Our ref.: MP10_0168

Subject: Exhibition of Mixed Commercial and Retail Development, 2 Australia Avenue, Sydney Olympic Park (Site 43/44) (MP10_0168)

The department has also reviewed the Environmental Assessment (EA) and requests that in addition to addressing the issues raised within the submissions, further information and consideration be given to the following.

drawing
MASTERPLAN - TYPICAL
BASEMENT

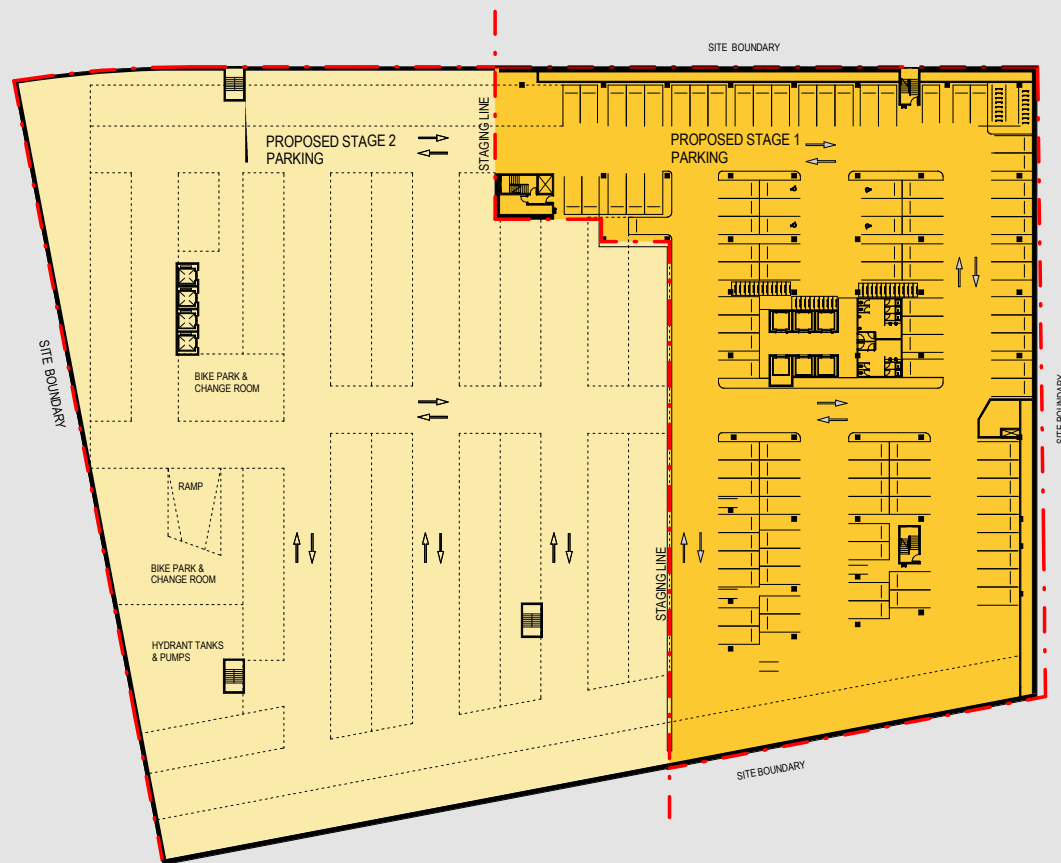
- Further to the comments provided within the submission received from the Roads and Maritime Services, the department requests that the evidence supporting the alternate parking car parking rate applied to calculate the car parking provision for the supermarket be provided.
- The location of the temporary basement access ramp will be impacted upon during the construction of the future east-west street, effectively restricting access to the basement car park. Accordingly, the at-grade car parking and basement access ramp shall be reviewed to ensure unobstructed access is maintained at all times, until final access arrangements to the basement car park are operational.
- Architectural details of the proposed revised car parking spaces of the existing warehouse are to be provided.

ACCESS TO TRAIN STATION

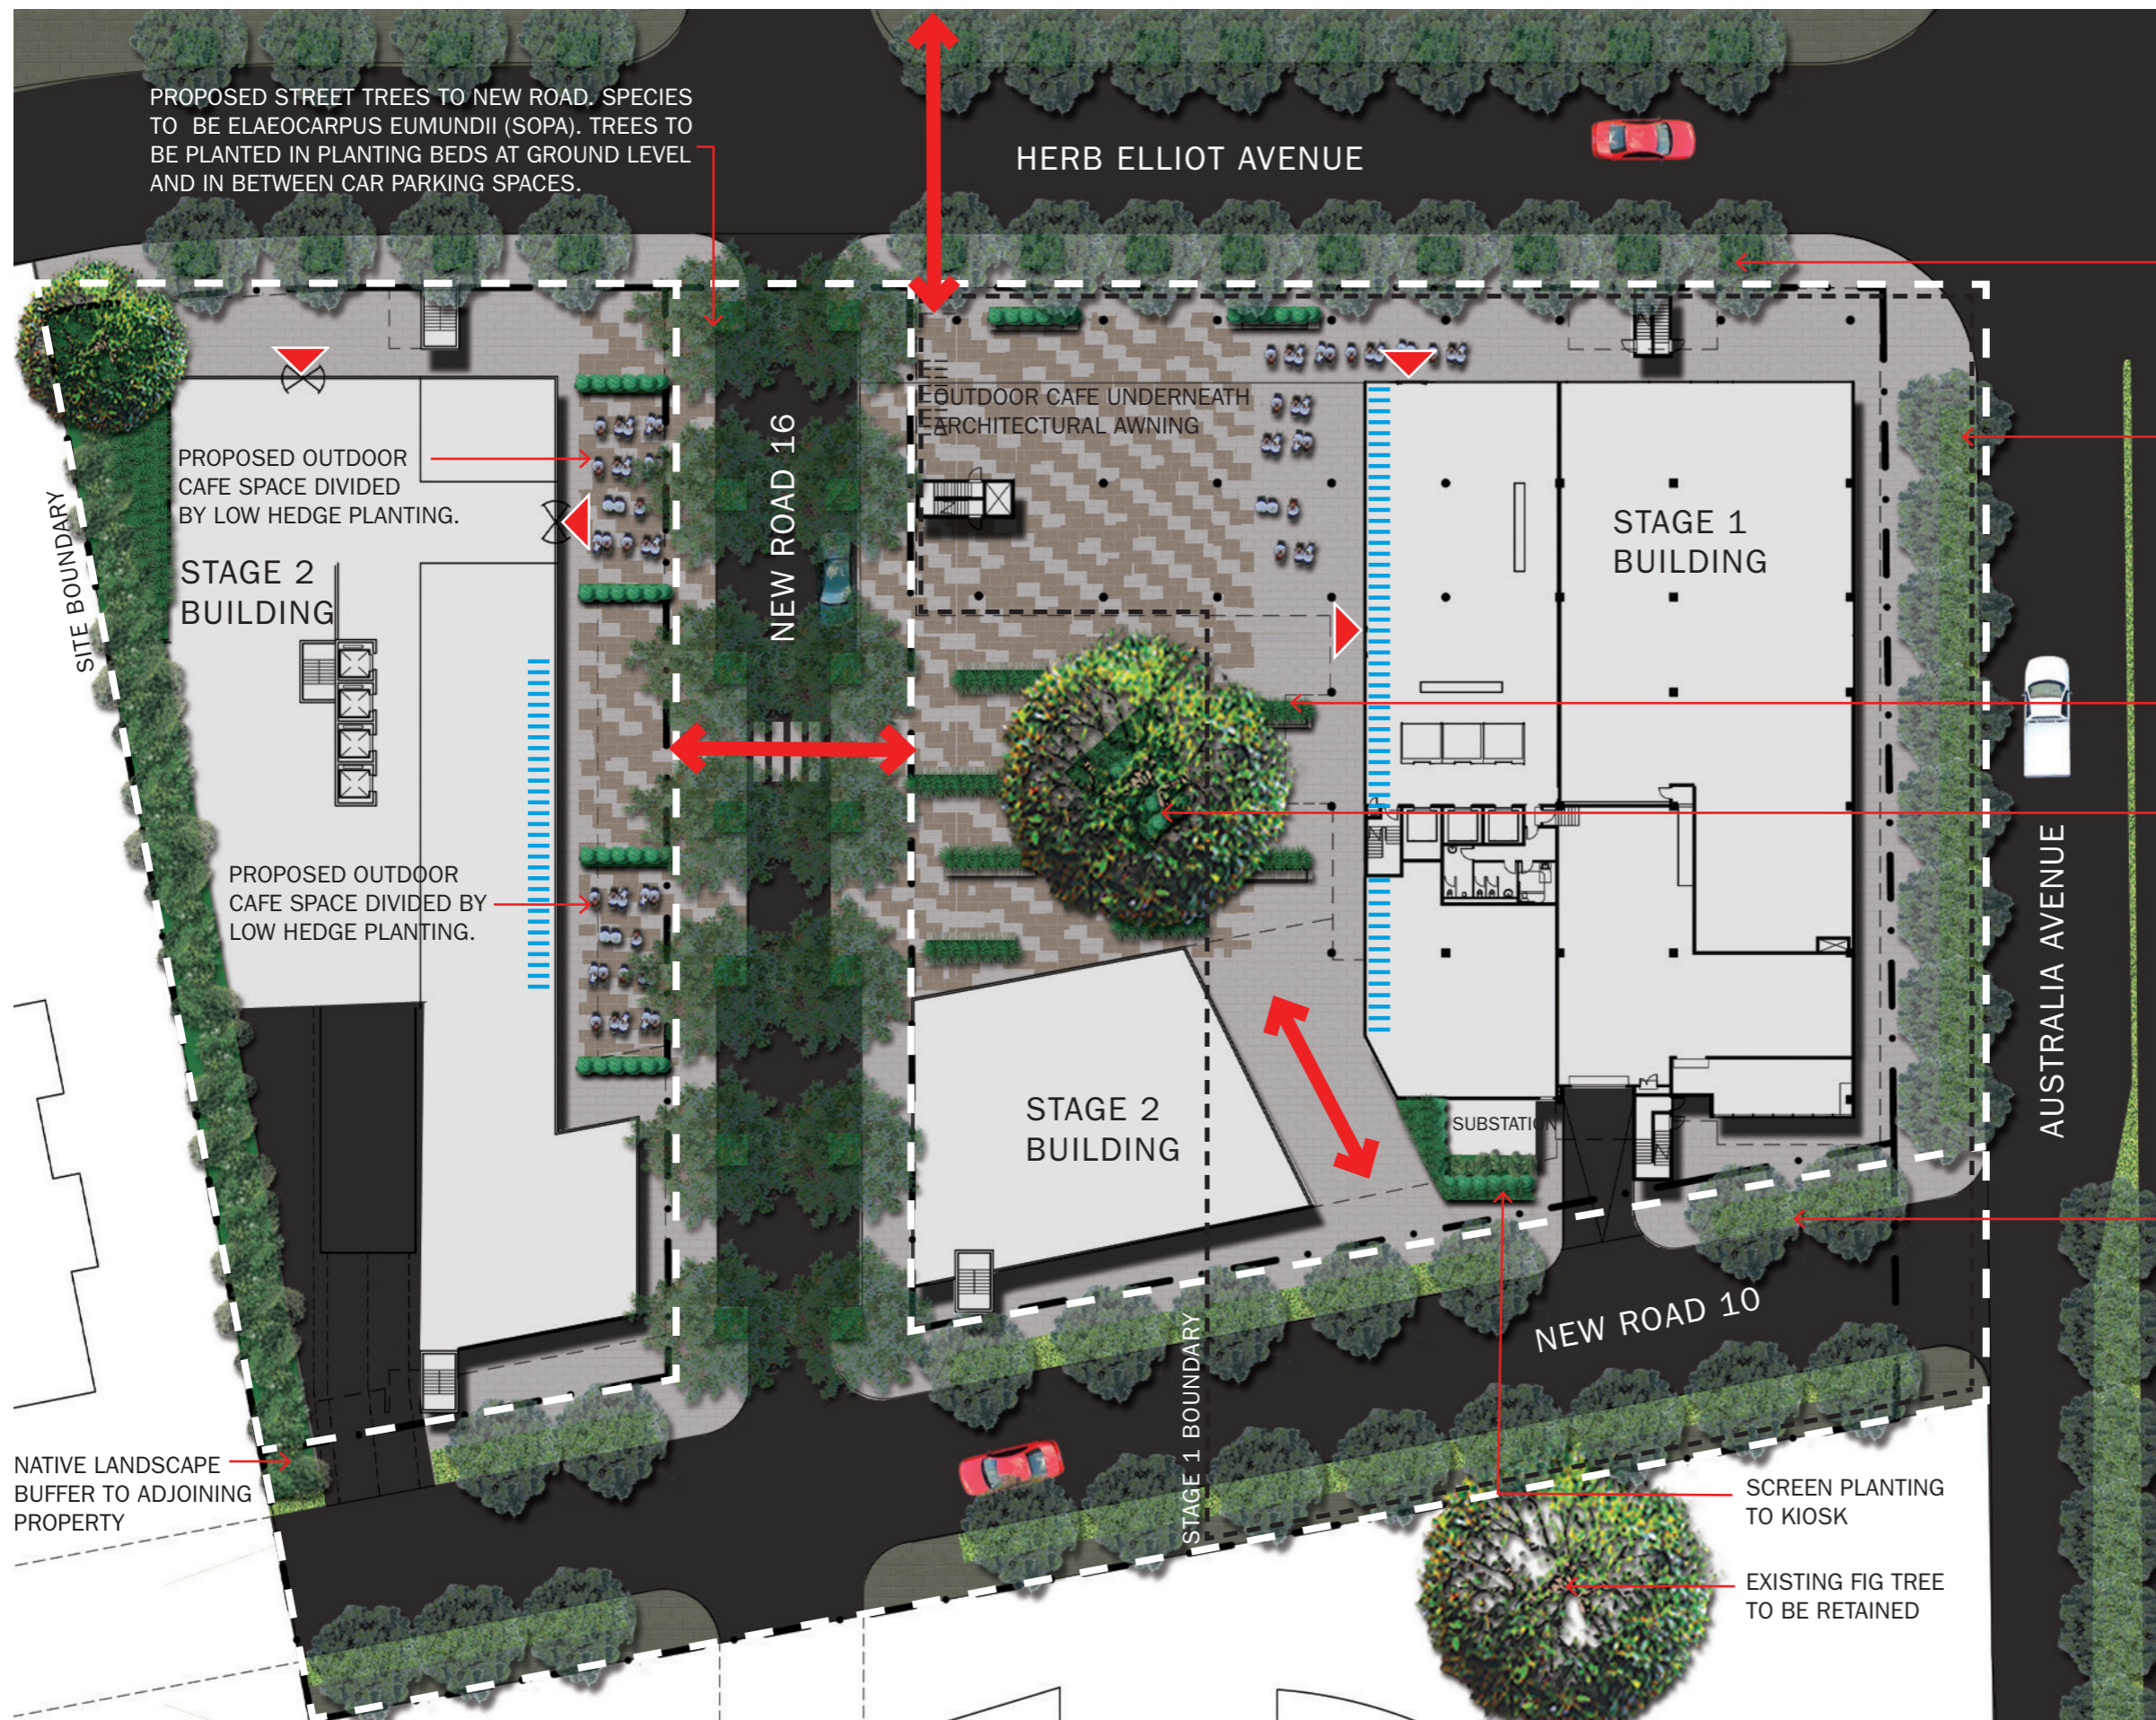
- The proposed layout of the supermarket at ground level has the potential to result in a lack of activation along Australia Avenue. Details of pedestrian entries into the supermarket are to be provided and pedestrian access to the basement car park is also to be resolved.
- The southern elevation of the proposed development should be setback a minimum 3m from the required 20m corridor of the future east-west road and details provided, demonstrating that the proposed development is clear of the required 20m road corridor.
- Design solutions should be explored in an effort to integrate the proposed electrical substation into the built form to reduce its impact on the public domain and the role the surrounding public domain will play in providing a key pedestrian link through the site.
